**Harnett County**  
420 McKinney Pkwy  
LILLINGTON, NC 27546  
Phone:  
Fax:

**SUBJECT: BRES2303-0003**  
**BUILDING RESIDENTIAL**

Here are the results of all Inspections located at **367 TROY PARKER LN:**

STAIR / PLATFORM DETAILS FOR

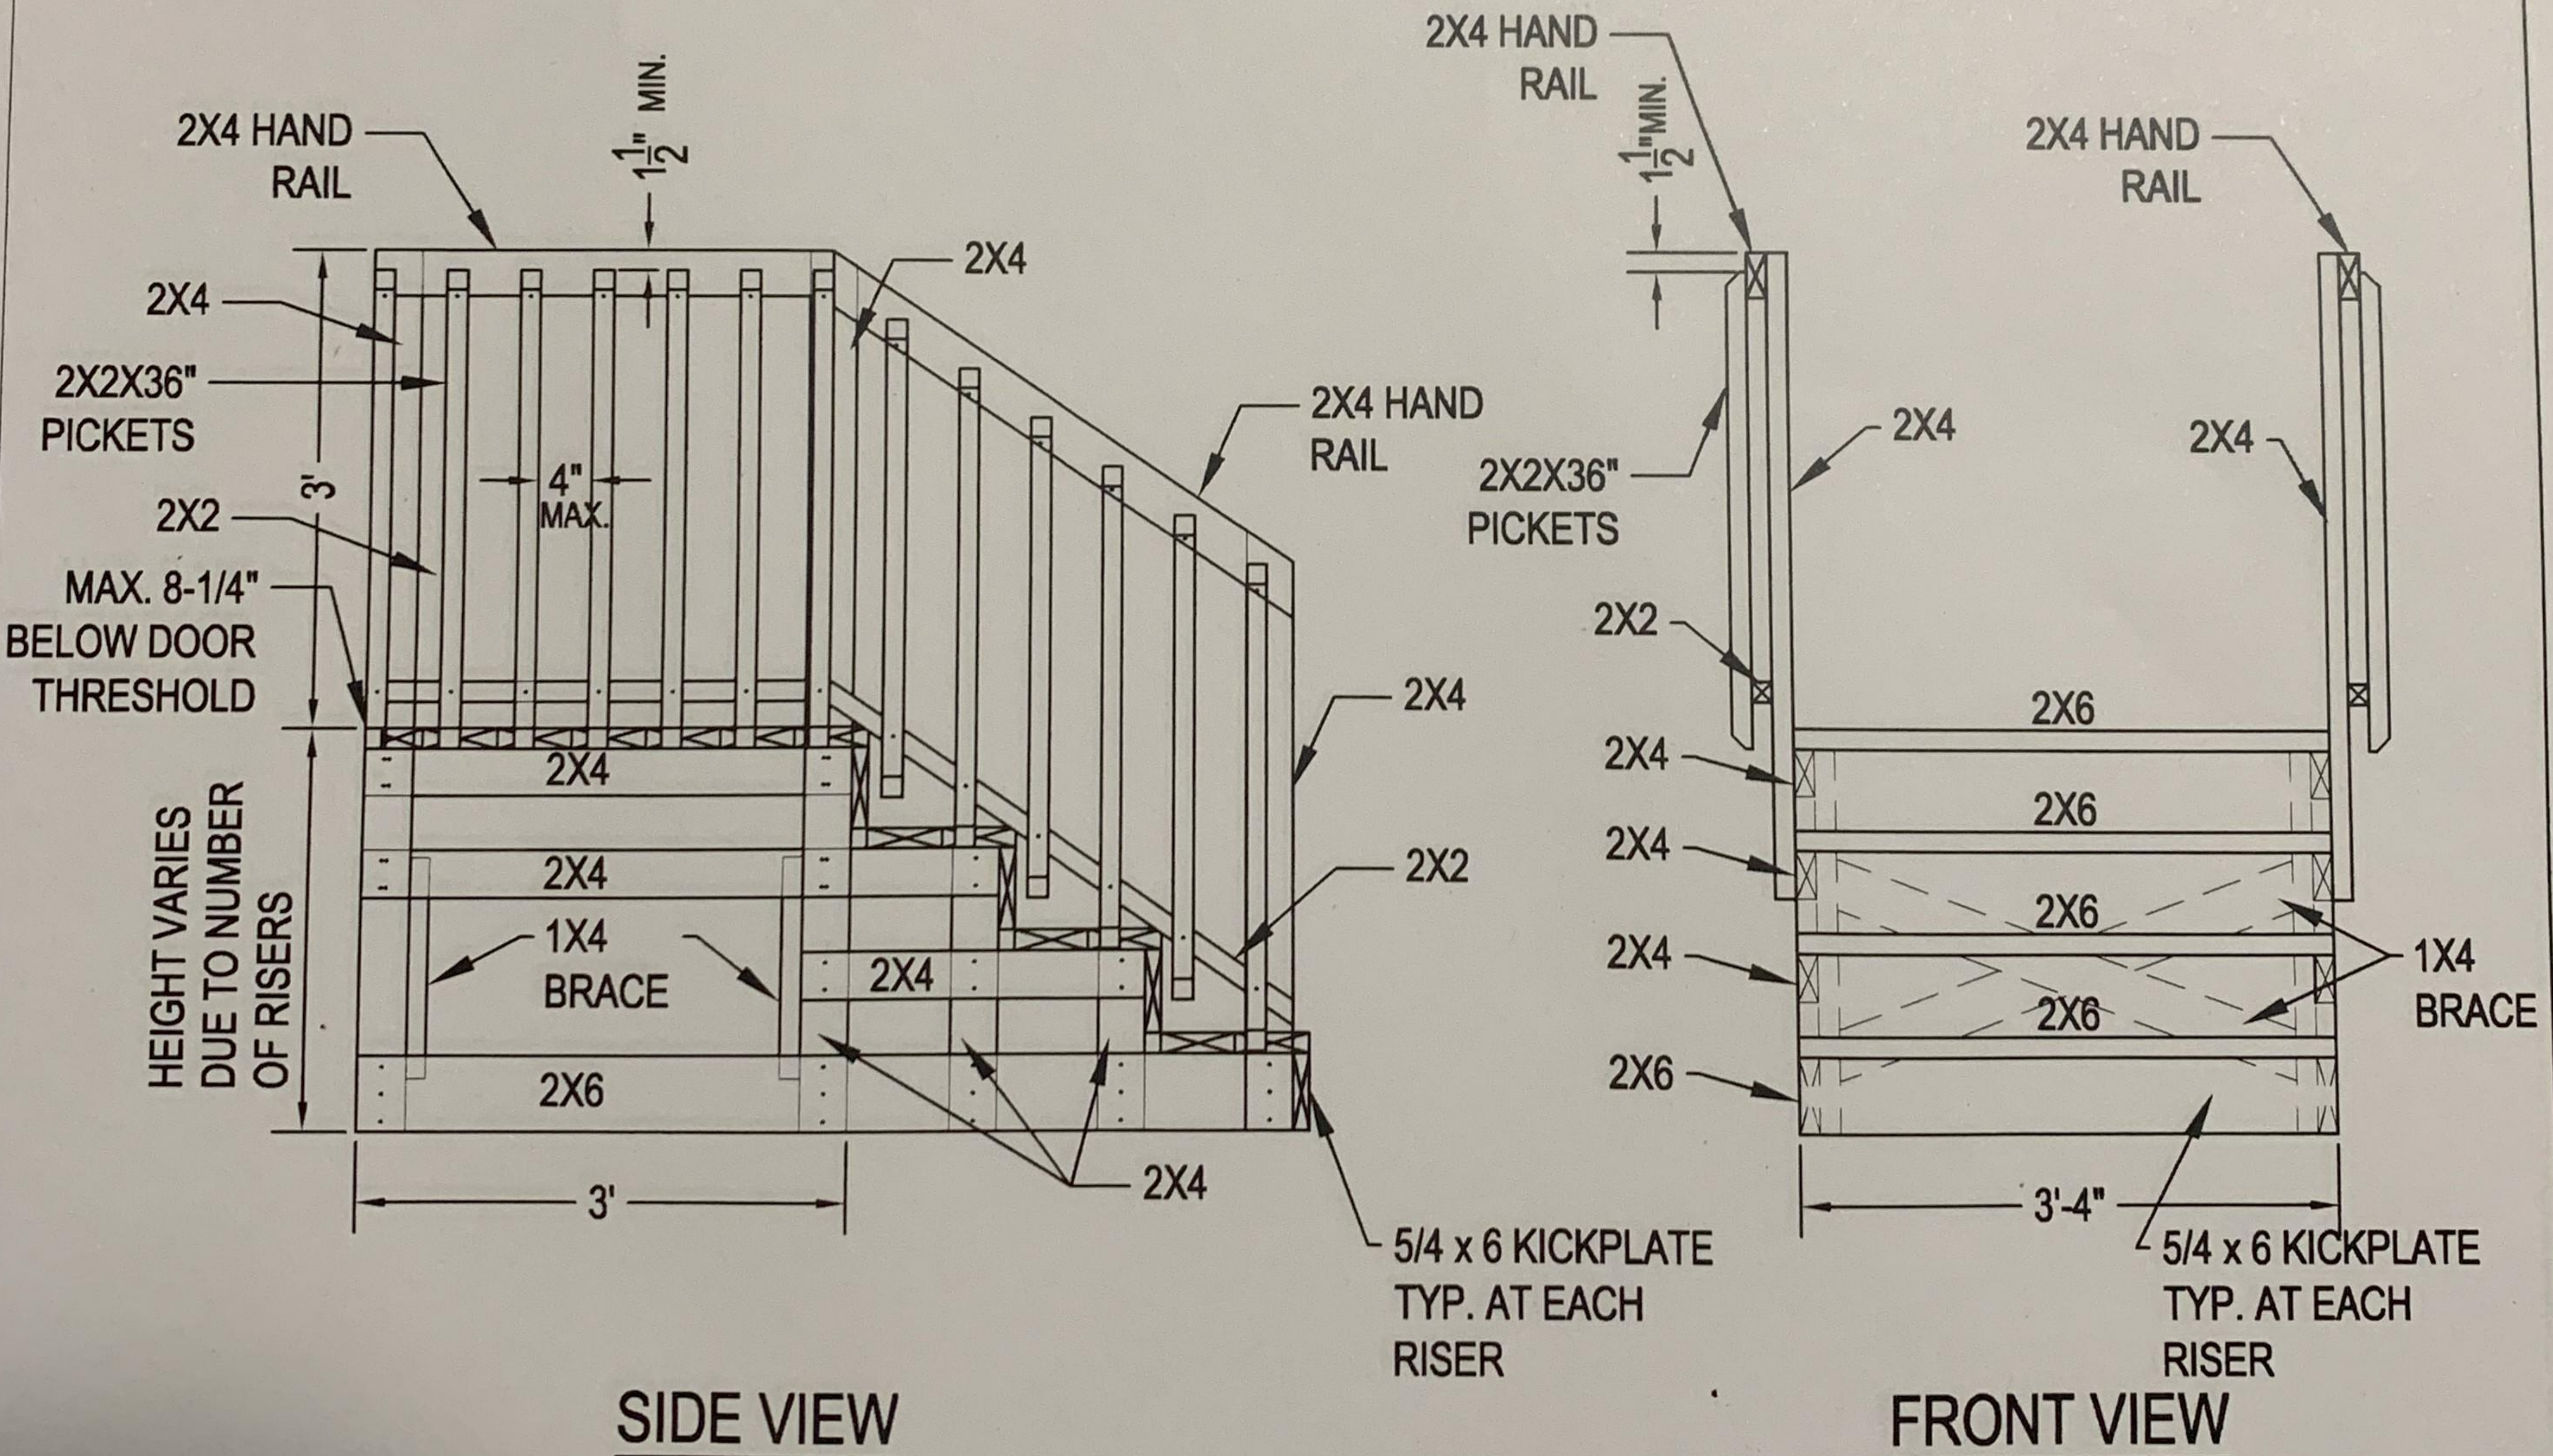
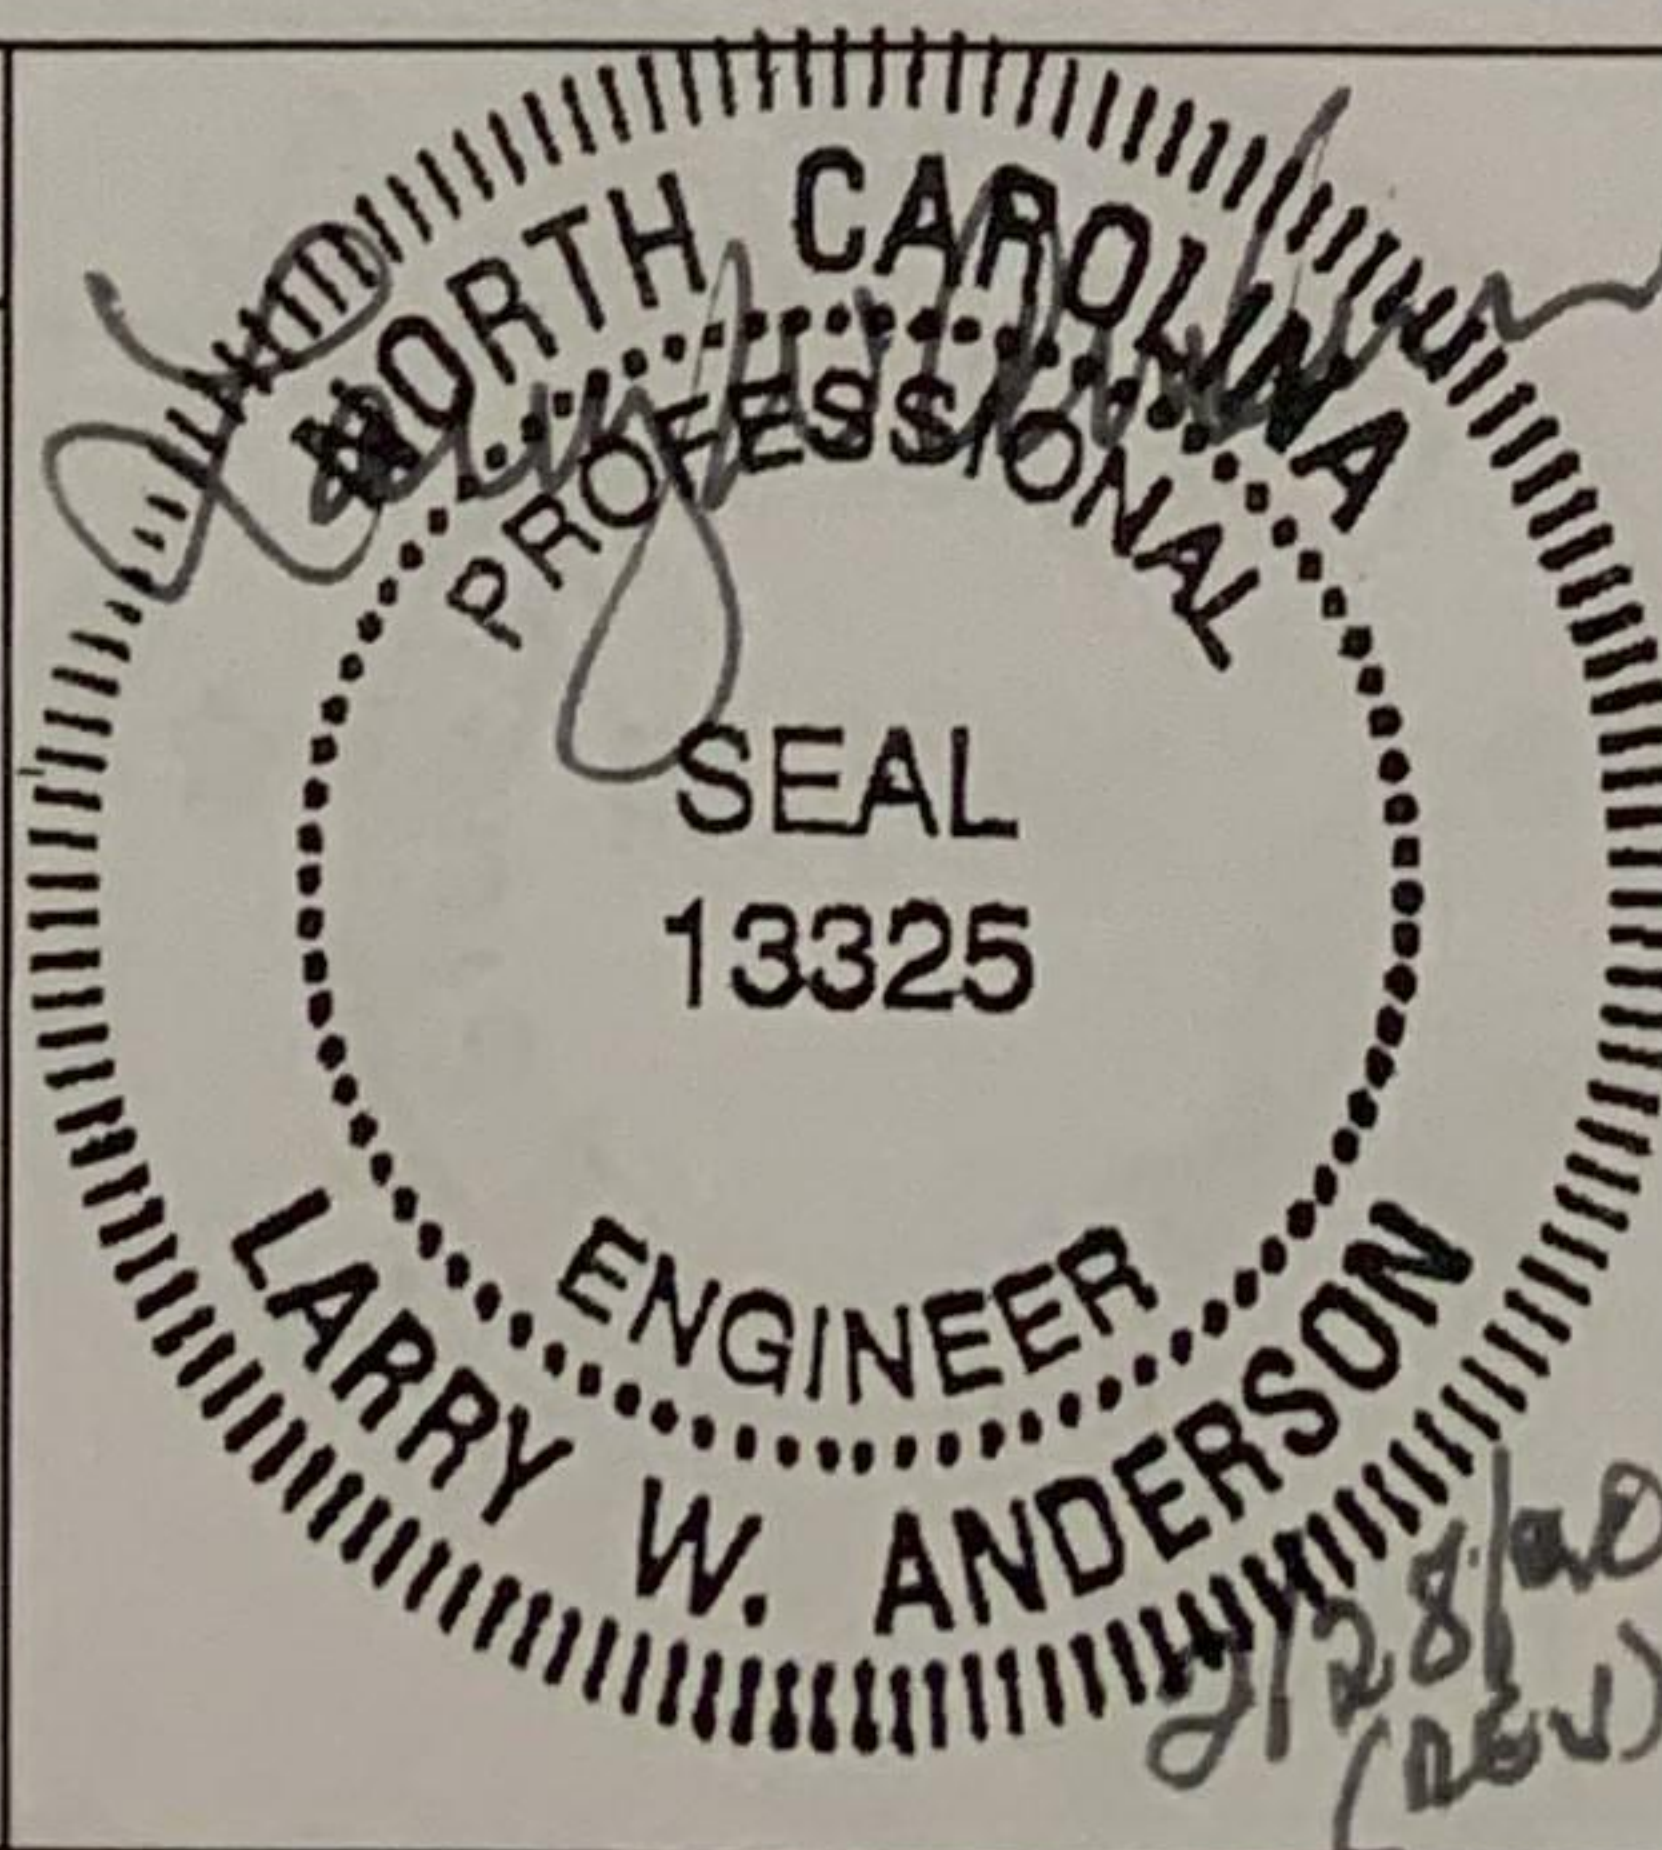
House numbers must be in contrast and color to home. Front and rear steps must be stabilized, and all guard rail pickets must be secured (stabilized means able to withstand 200 pounds of pressure in any direction without moving). Handrail for front and rear steps must be graspable

Stairs/Guardrails must withstand 200 lbs of force without moving. Top of guardrails must be graspable.
